Application No: M/91/21/PL
Site Address: 27 Central Drive Middleton-On-Sea PO22 7TT
Description of works: Variation of condition 2-approved plans & removal of condition 4-materials included on plans imposed under M/25/19/PL.

Thank you for your internet representation made on 3rd August 2021 which has been recorded as an objection with the comments as follows:

PROJECT	27 Central Drive - Elmer Beach	DATE	16/09/18
TITLE	Proposed South Elevation	DRG NO	IBA/507/05
SCALE	1 : 50	REVISIONS	B

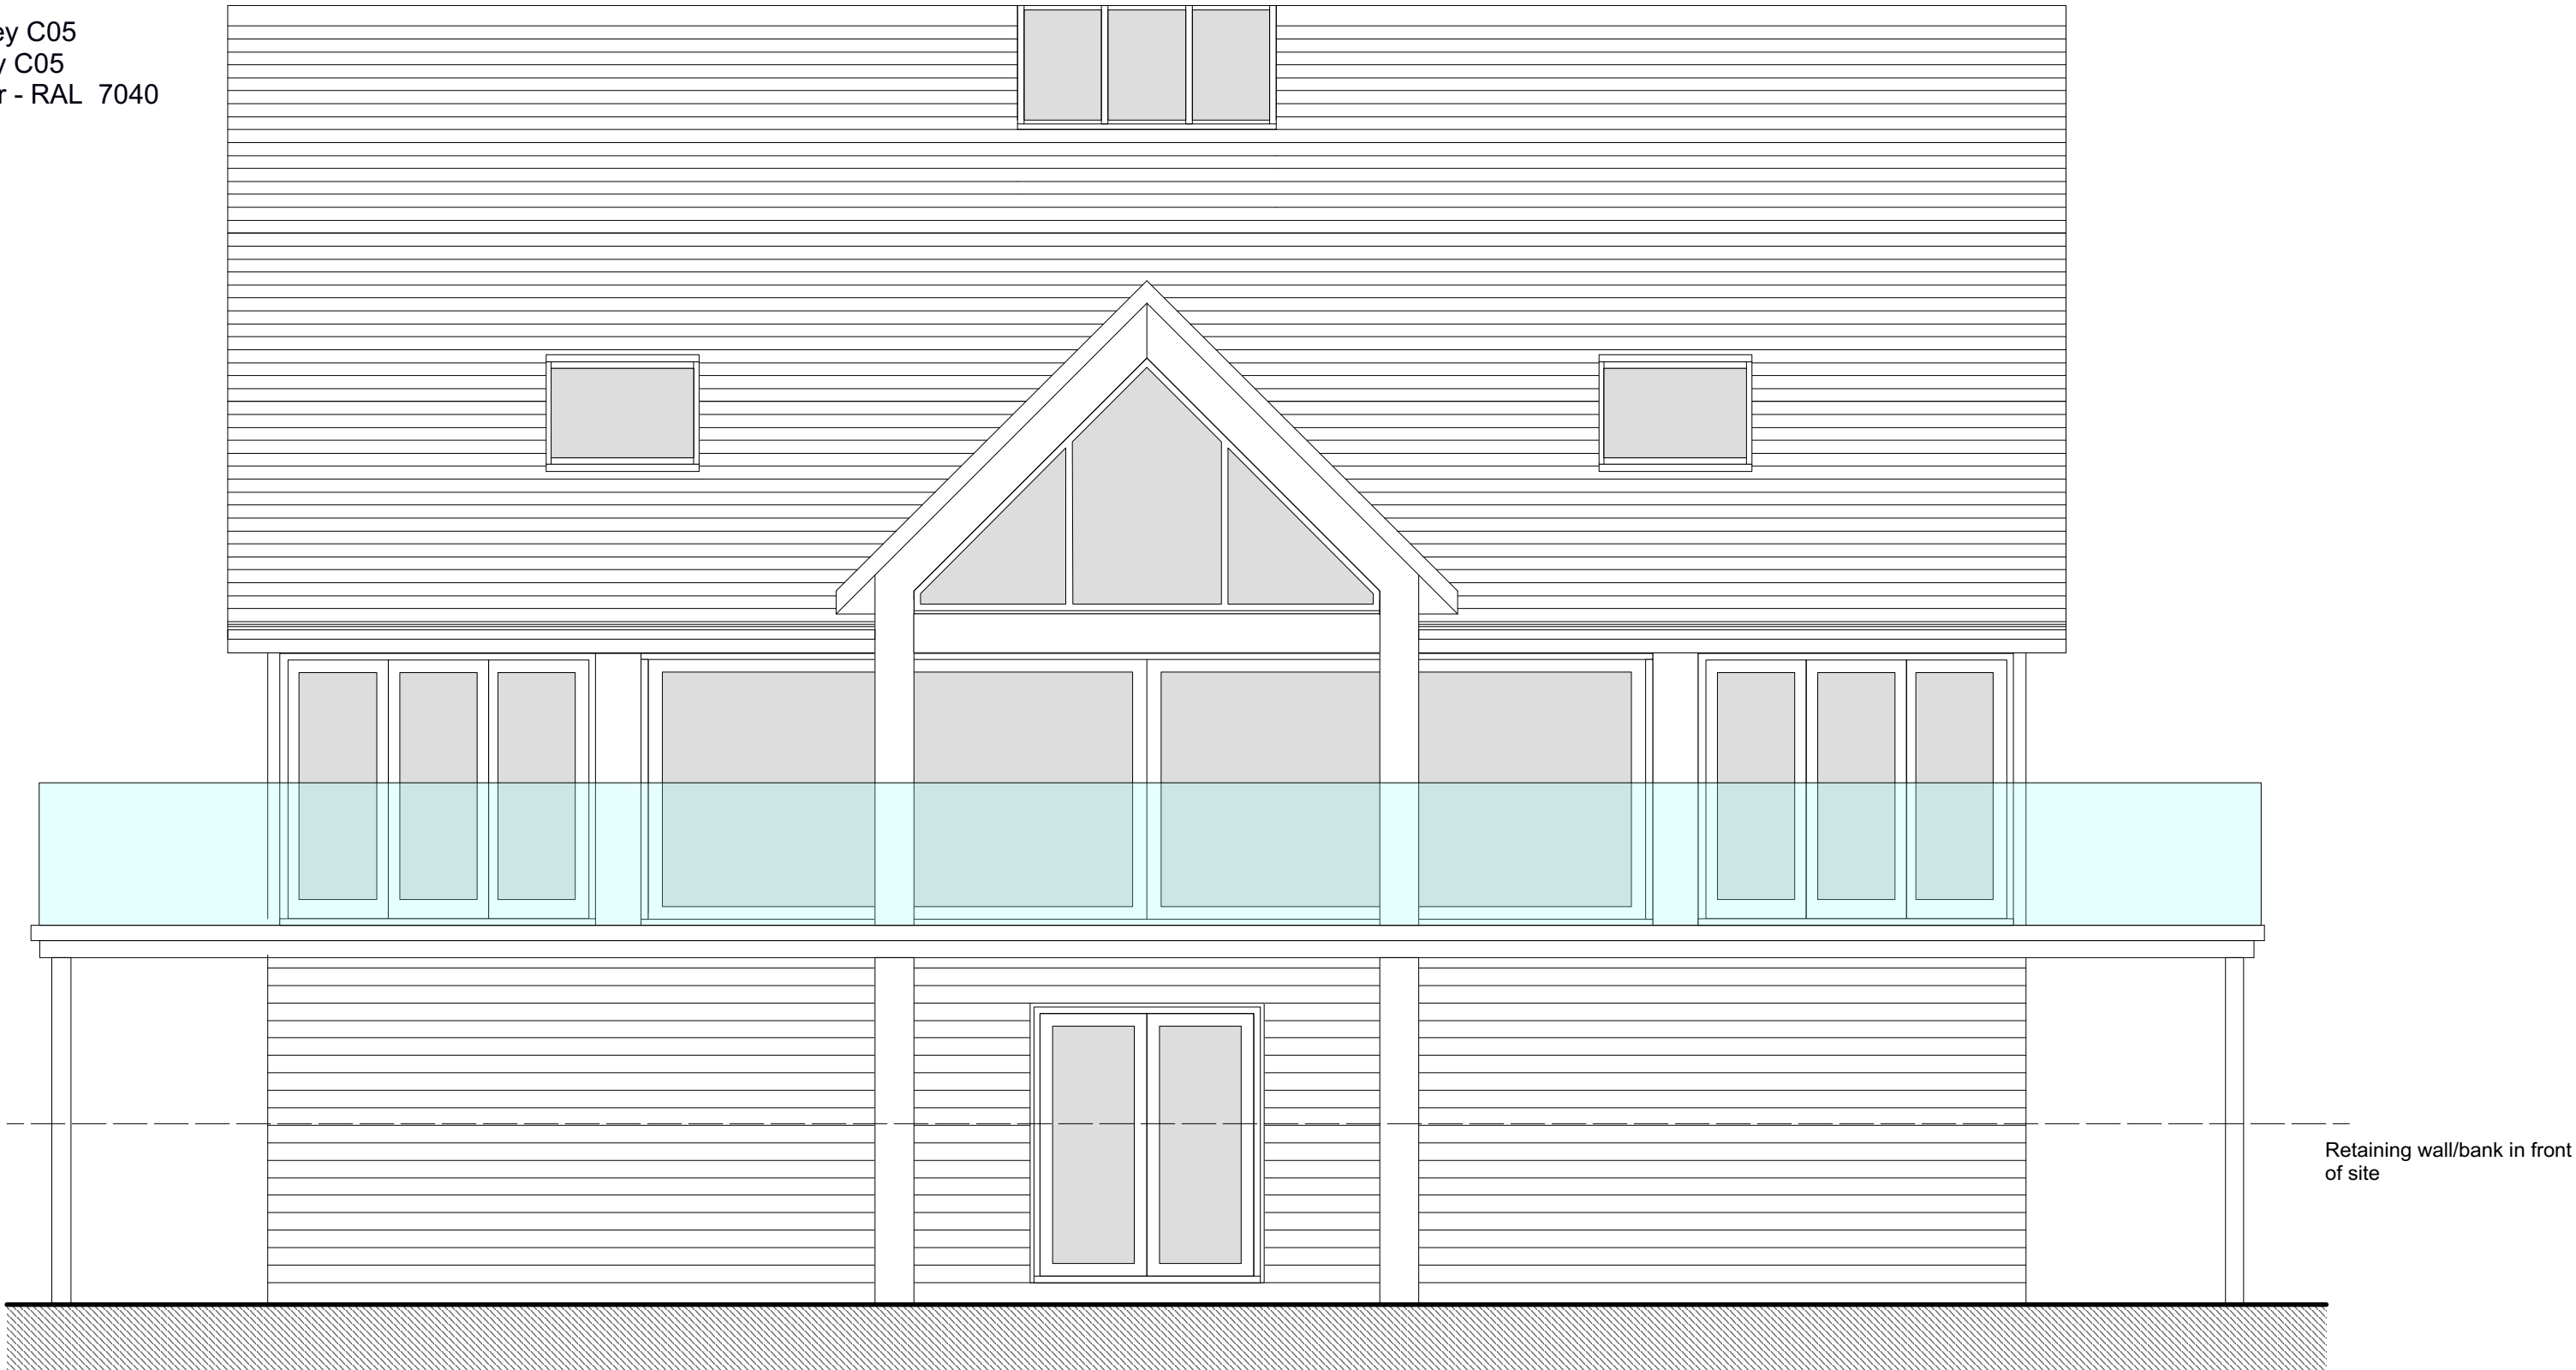
It is now clear that the height of the building is significantly higher than the immediately surrounding properties, including most obviously the property immediately next door, New England. The property is overbearing, particularly from the beach, and clearly very different from the street scene document attached to the original application. Any member of staff from the planning office would see this if they came to visit and viewed the property from the beach. We cannot see any logical reason why Arun District Council would allow a residential house to exceed the height of the existing skyline by such a substantial amount and we are therefore writing to formally object to this application. We leave it to Arun district council to decide on this matter in a fair manner to all local residents who see this property as unnecessarily dominating the beach view.

"It's impact is reduced due to the flood bund and beach landscaping that rises up immediately behind the property which obscures the ground floor and breaks up the appearance of the new build such that no significant impact on the existing beach front scene would occur. The spatial pattern and character of the locality would therefore be retained and improved as a result of this development."
